KITTITAS COUNTY DEPARTMENT OF PUBLIC WORKS

MEMORANDUM

TO: Graham Simon, Community Development Services Planner II
FROM: Randy Carbary, Planner II ✓
DATE: Oct 20, 2005
SUBJECT: Bailes BLA

REQUEST FOR PARCEL SEGREGATION AND BOUNDARY LINE ADJUSTMENTS

**BAILES PROPERTY**

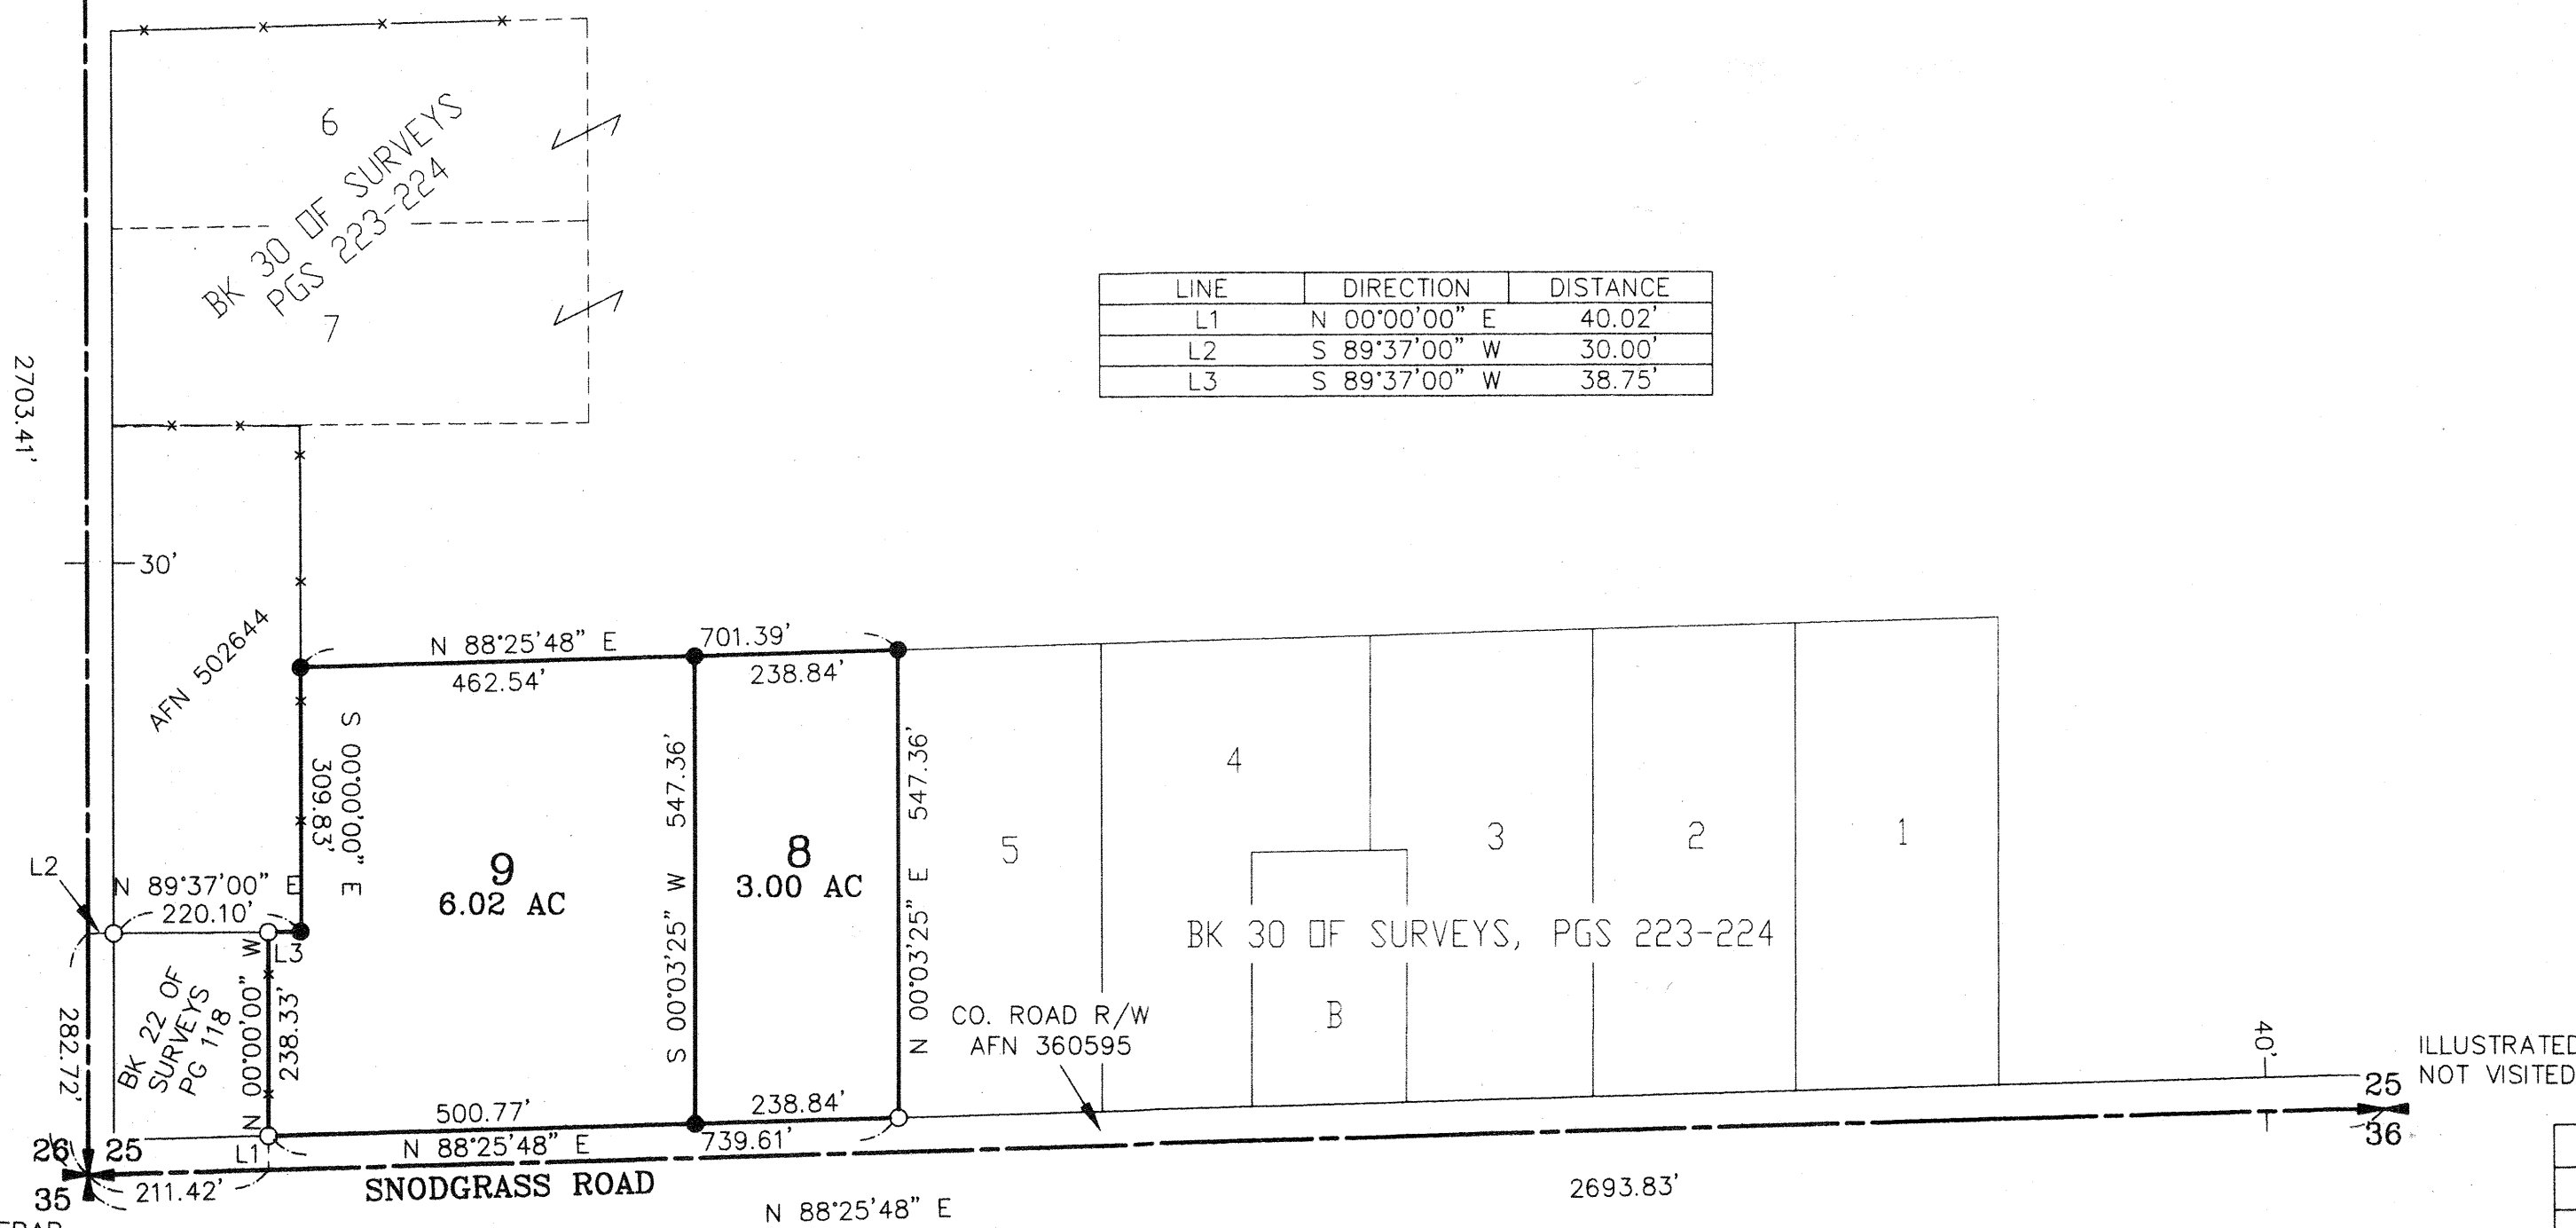
1. Prior to Final Approval the proposed access with appropriate easement(s) shall be shown and shall conform to applicable Kittitas County Road Standards.
